AT&T
Mobility

SITE NAME:
NSB-CO.BDN_ADD_4591_COL02148_PeyTON

SHEET TITLE:
TOWER ELEVATION

Elevation Plans_V1.pdf Markup Summary

C-4

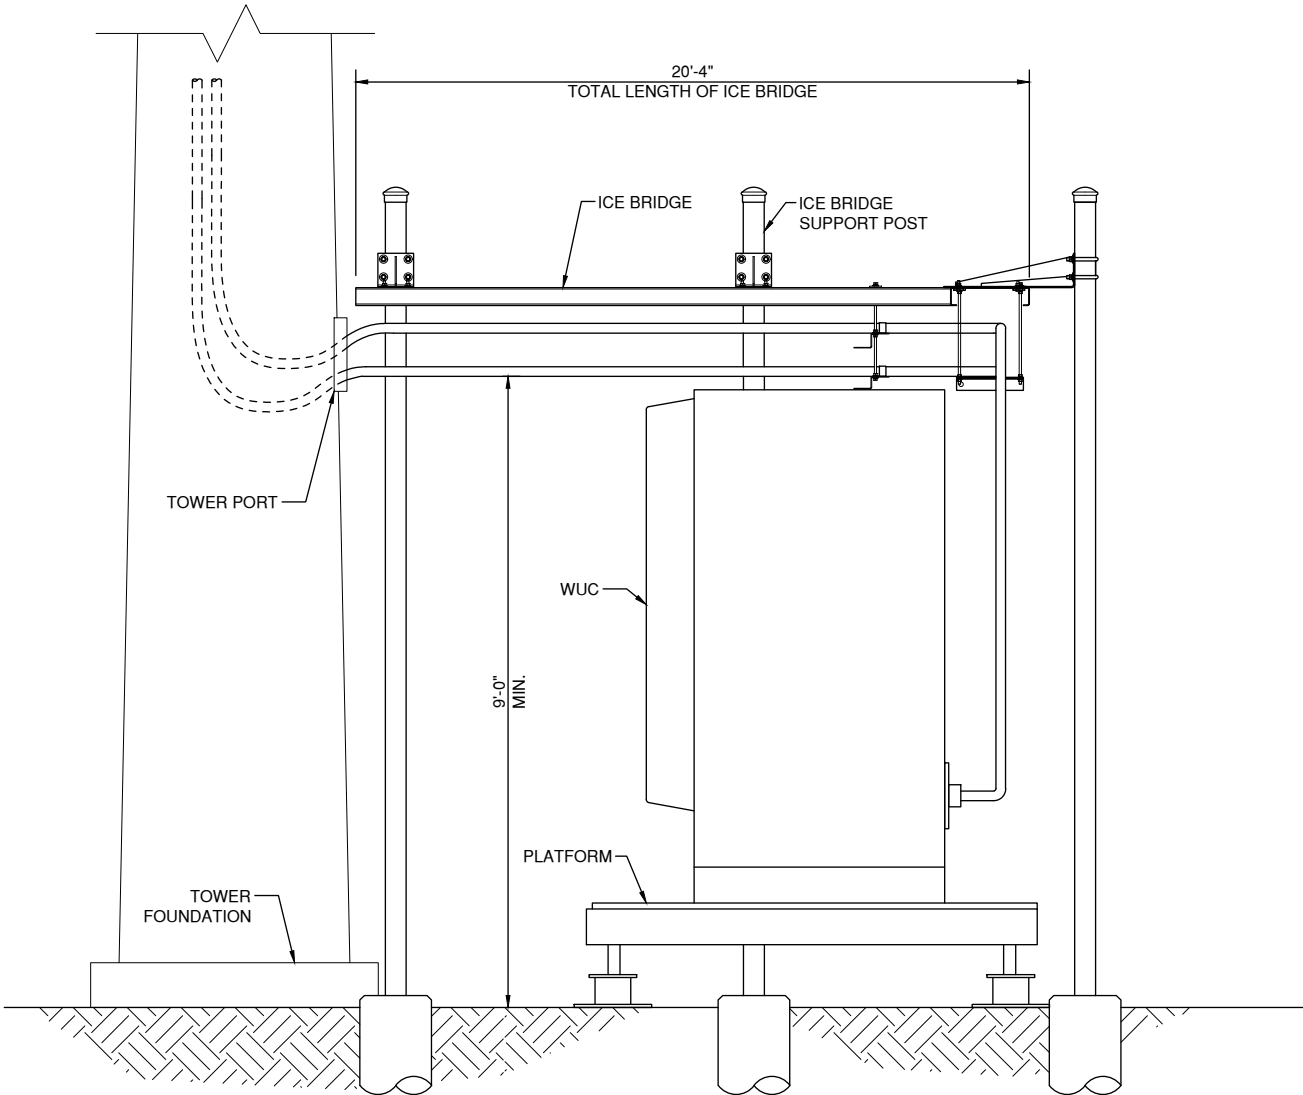
119' height has already been approved. Please revise to note "existing" or "approved tower" and "approved monopole extension".

Proposed 6-foot microwave dish exceeds Land Development Code allowance max. of 4-feet
